Application number: 2024/90769	
What is the application for?:	Erection of one detached dwelling and associated works
Address of the site or building:	adj, 27, Riley Park, Kirkburton, Huddersfield, HD8 0SA
Postcode:	WF4 5NF

Type of comment: An objection	
Do you wish your comments to be published on the website anonymously?	No
I am writing to object to this planned development on the grounds of development site instability, visual and residential amenity, trees and flood risk. Instability of Site I have serious concerns regarding the stability of the banking on which this proposed development sits. It is clearly unstable and there is the potential of collapse and landslip. The building is proposed to be built very close to the 'cliff edge' of the banking. The proposed development being significantly larger than the previous application raises increased concerns about safety and stability of the land to be built on. The proposed development also now has a basement level which will require excavation into the banking. There is no scheme of works attached showing how this will be achieved and how the building will be constructed safely. The site is on an area of previous coal mining an

Drawn	Checked	Date	Scale	Revision
DB	AH	18/08/2023	1 : 100 @ A1	
Client	Rayner Developments			
Project	Belfry			
Title	Proposed Plans and Elevations			
Dwg No.	3106-002

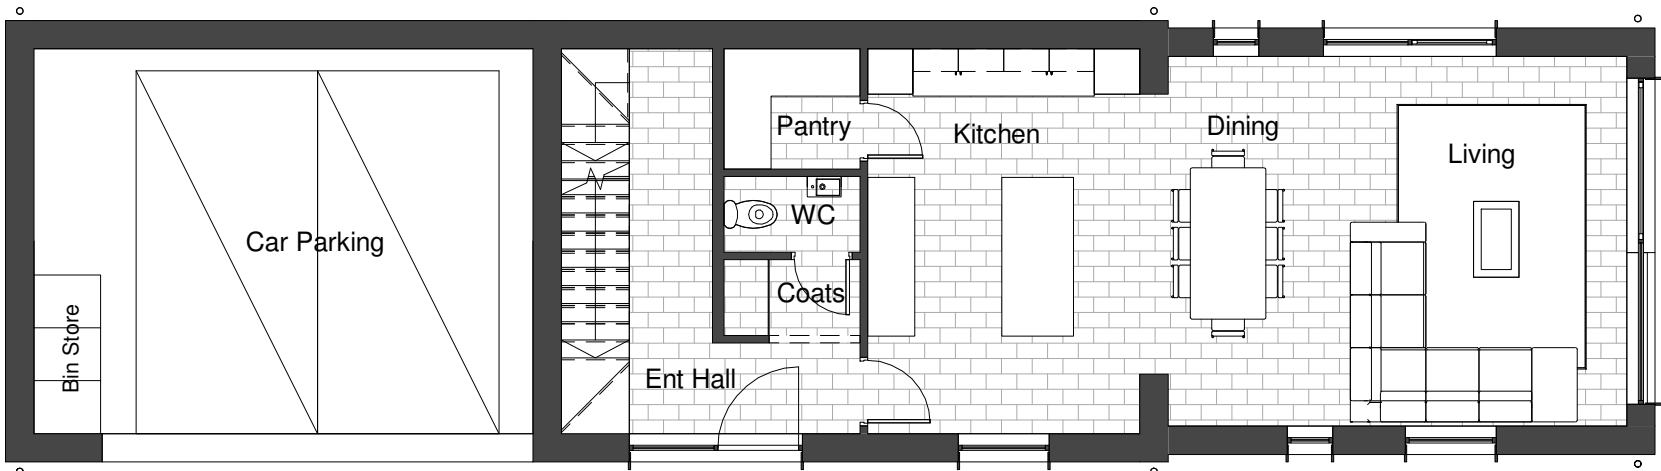
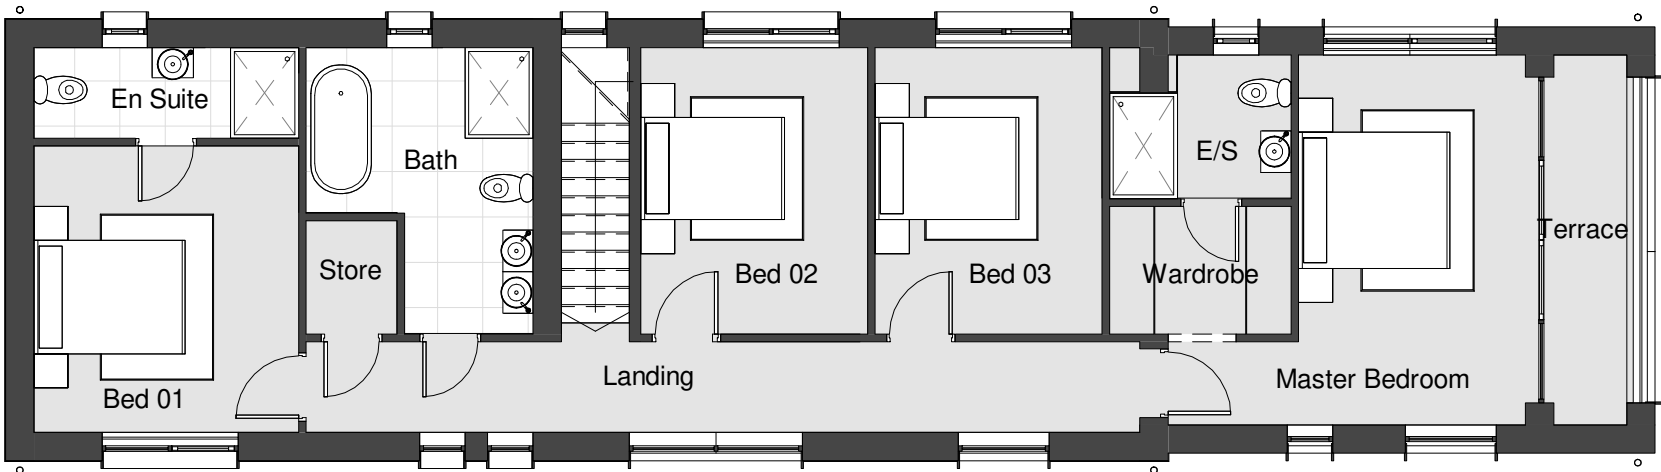
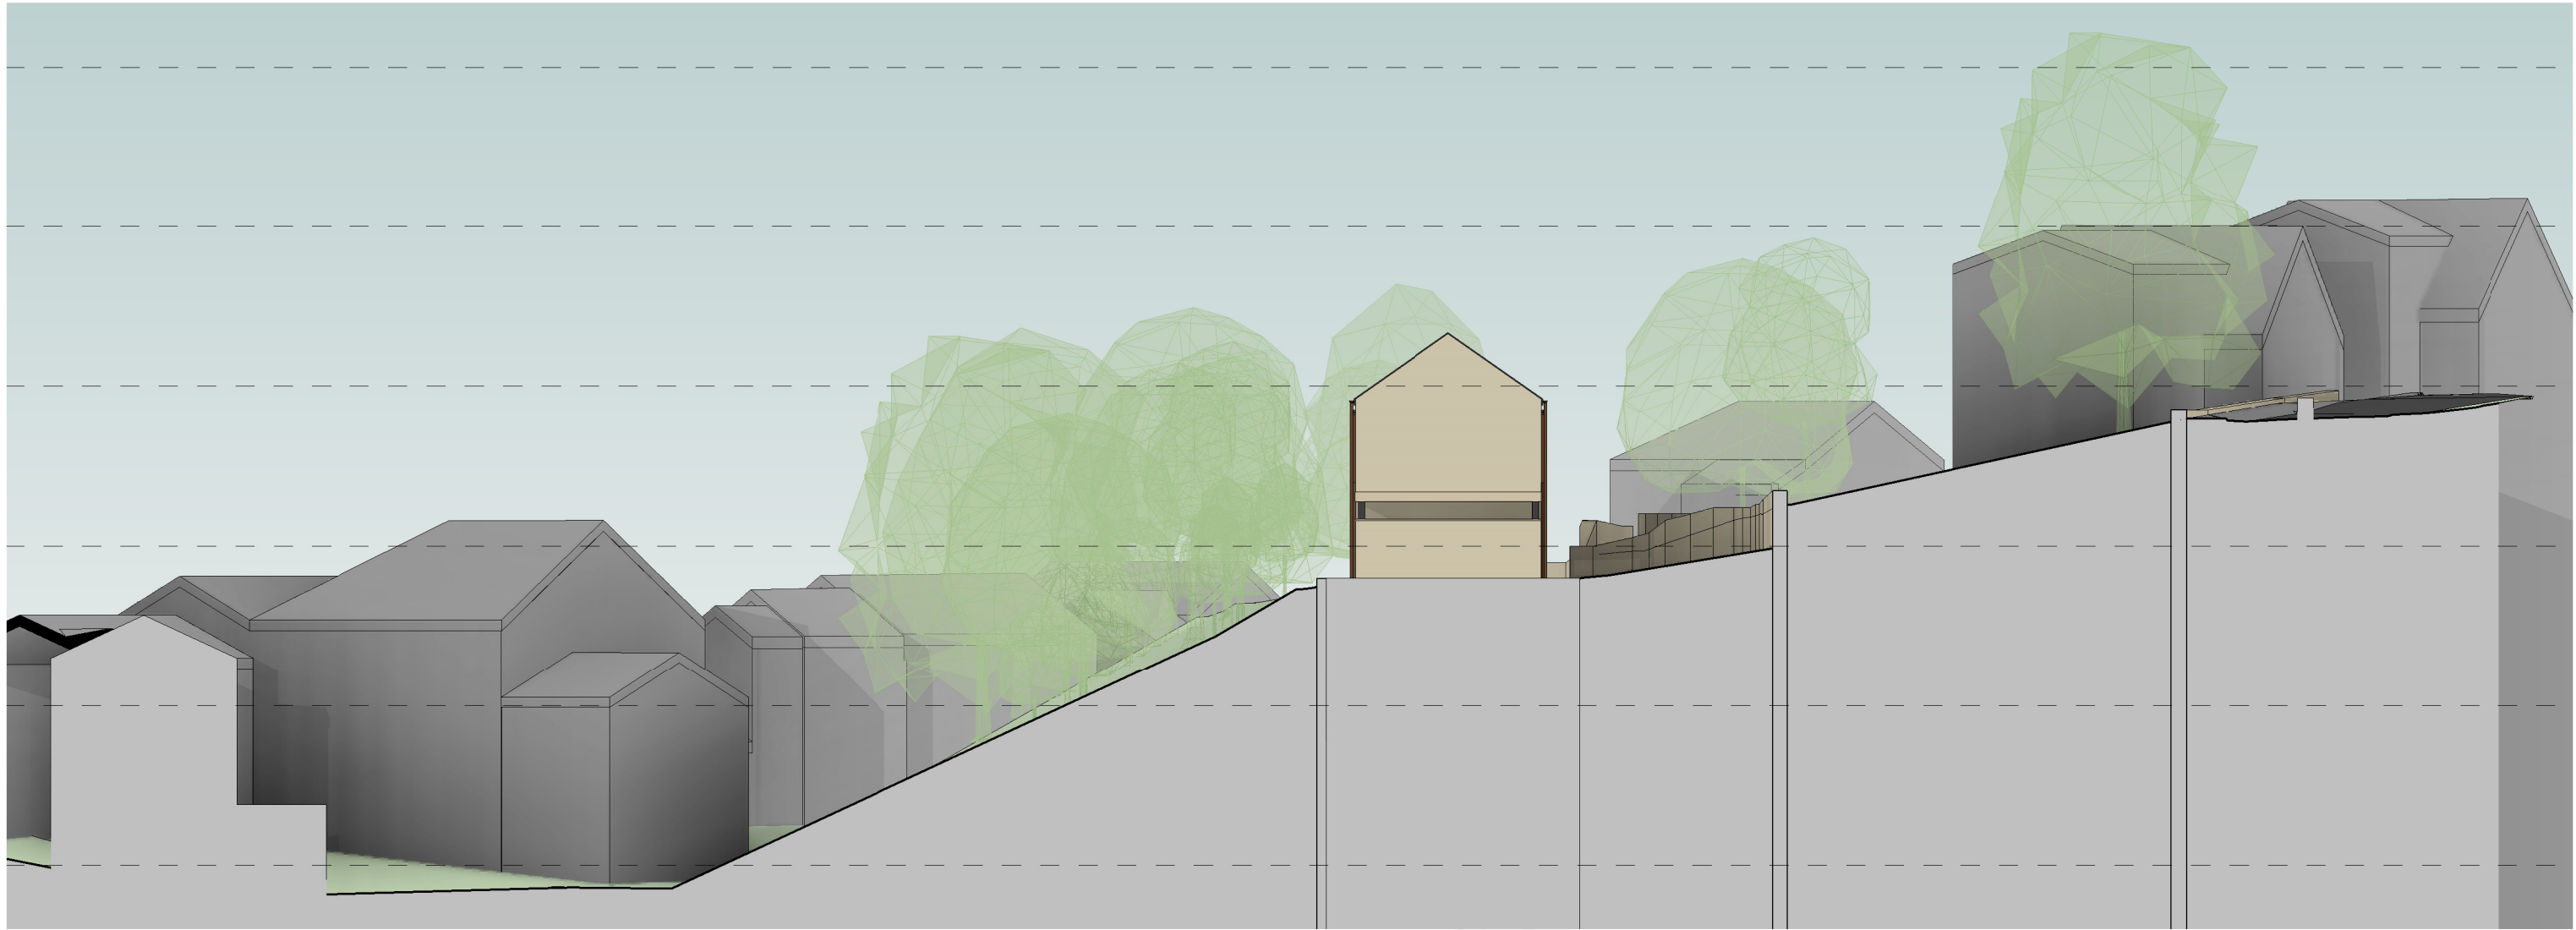
The size scale and form of the proposed development will have a negative impact on visual amenity.

The plot is long and narrow. The proposed development will be close to filling the plot and looks to be of a scale that will overbear neighbouring properties.

Extensive copper cladding and windows is not in keeping with neighbouring properties or the neighbouring conservation area.

There is a huge issue of overlooking to our property a number of windows looking directly into our garden and due to the 30 ft elevation giving a panoramic view of every aspect of our garden.

Title TREE CONSTRAINTS PLAN

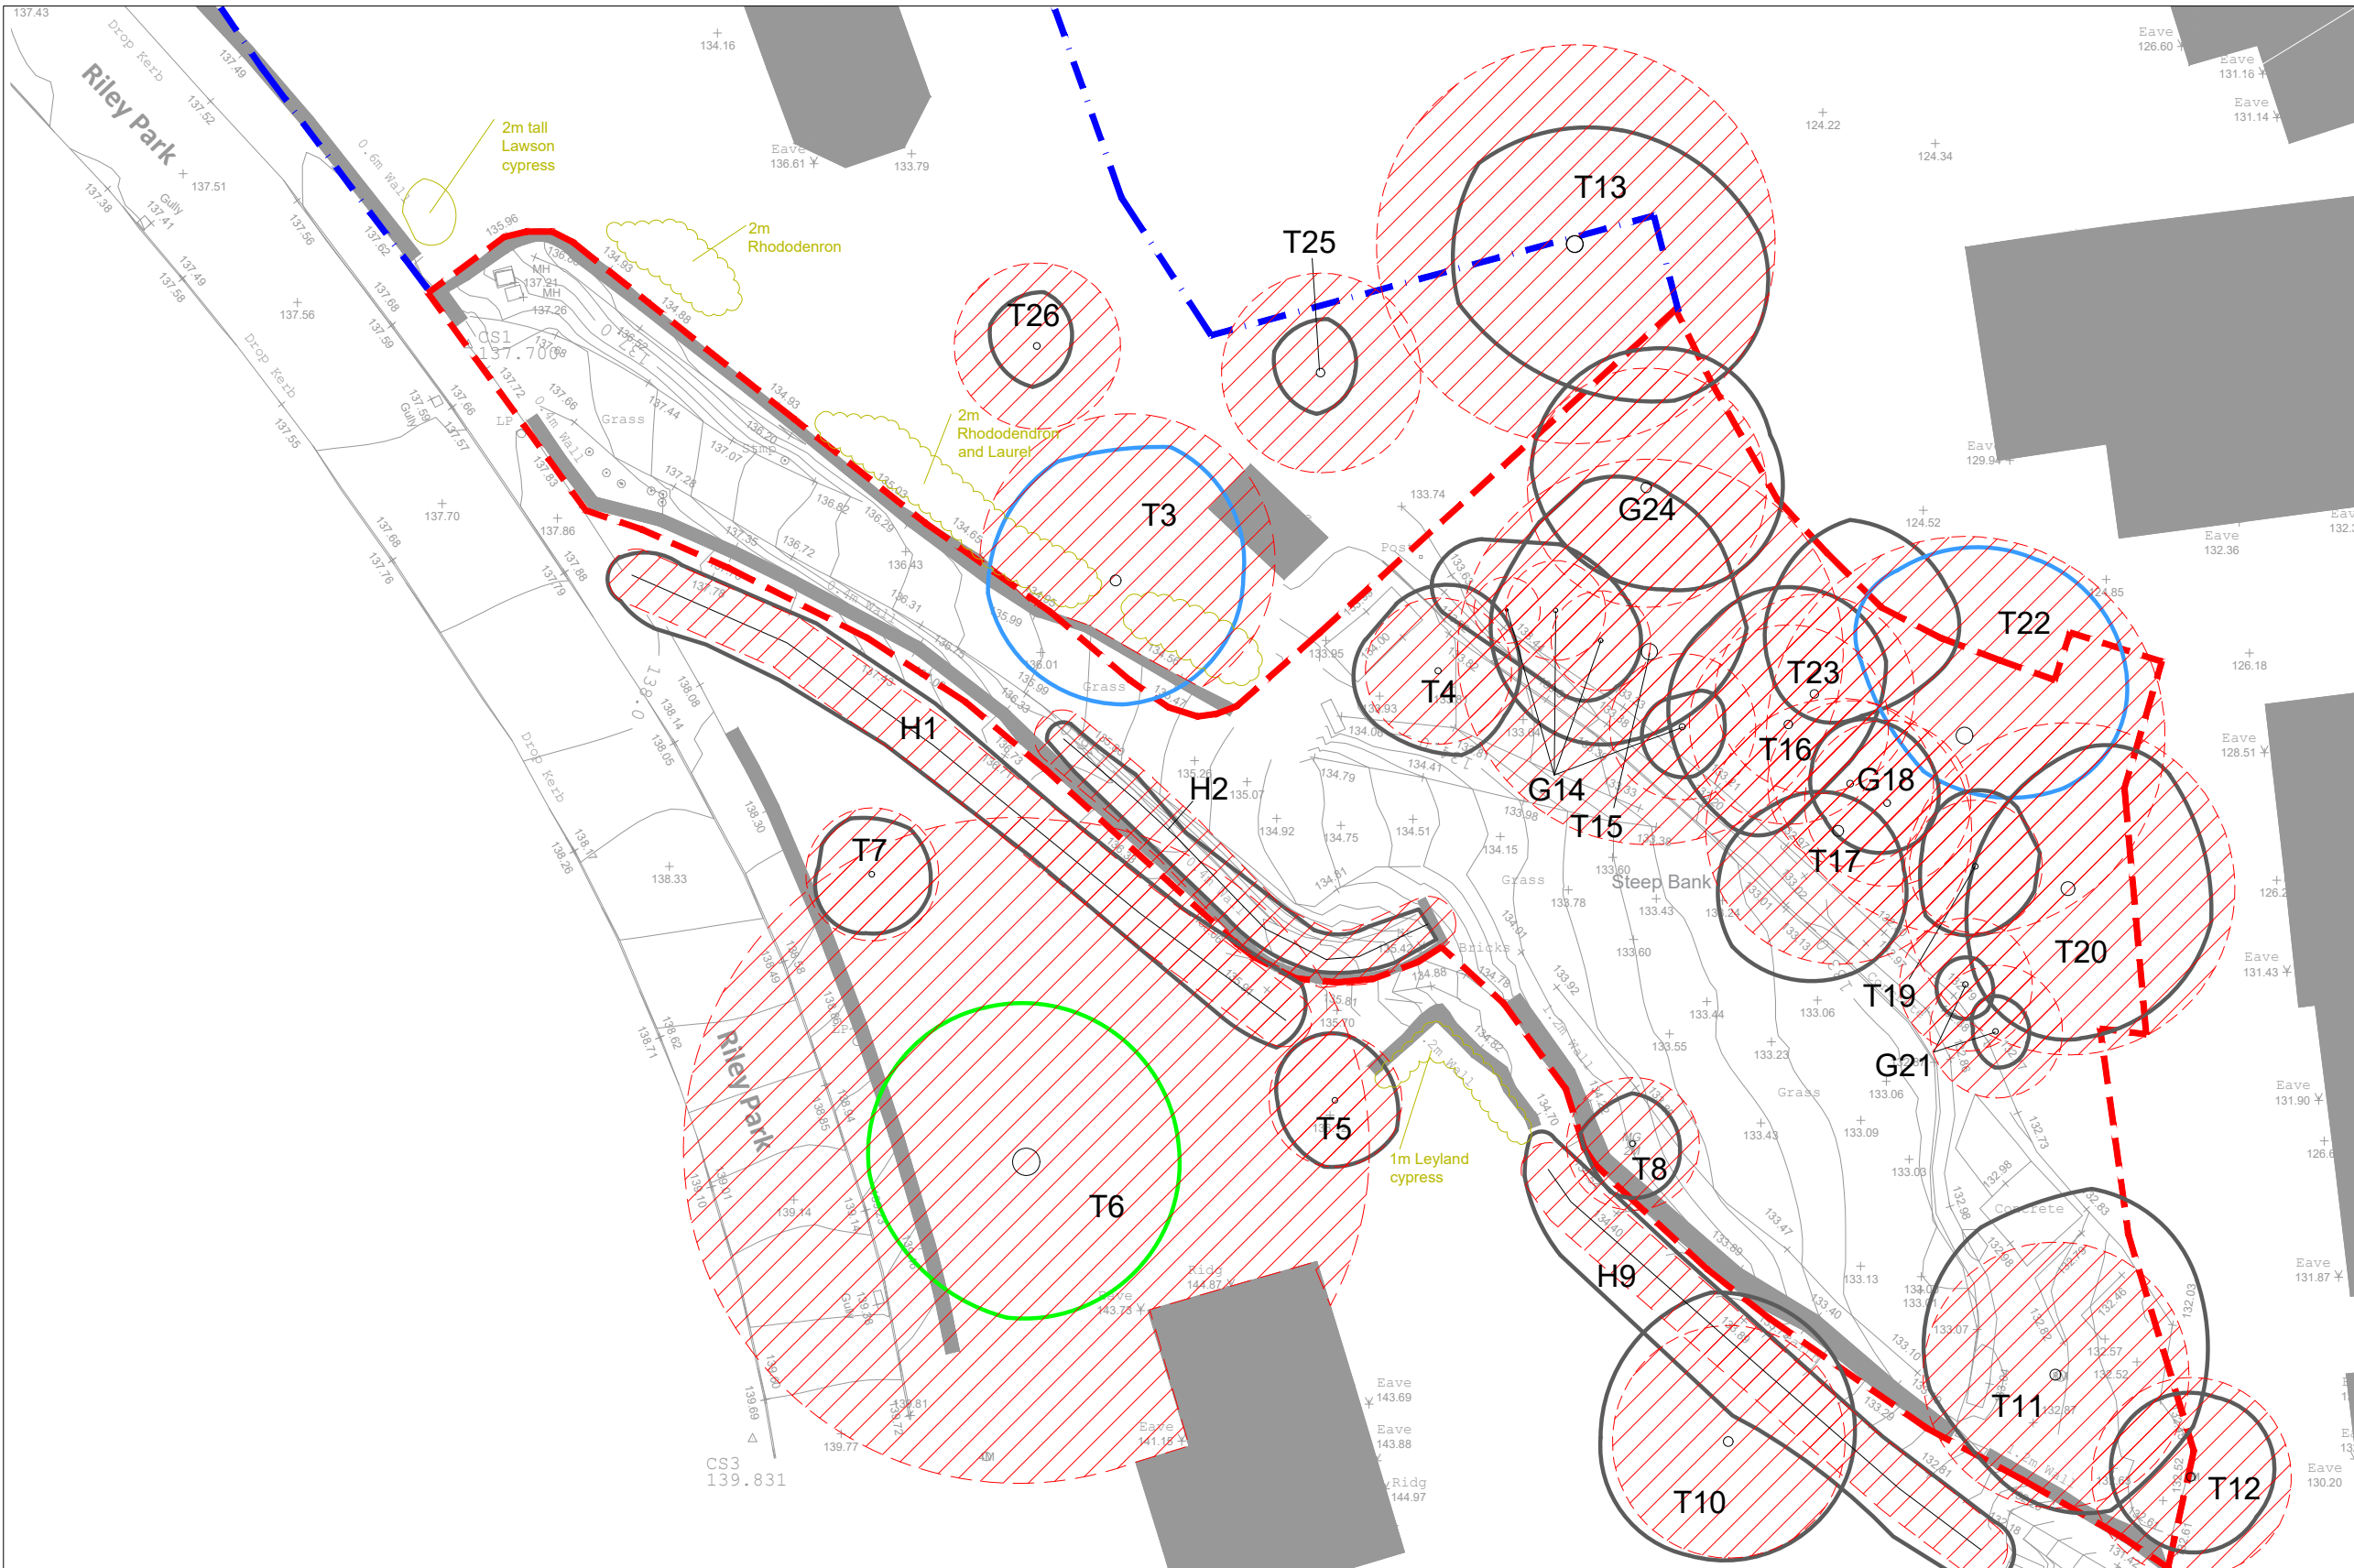
The proposal states that only a small number of trees in the mid section of the banking will be removed.

Due to the proposed development being constructed very close to the banking edge the trees on the banking edge would literally grow into the proposed development and

therefore many more will have to be removed. I heretore affecting the level of screening to ours and neighbouring properties and removing natural habitats for wildlife.

The removal of these trees will also in turn increase the instability of the already unstable banking.
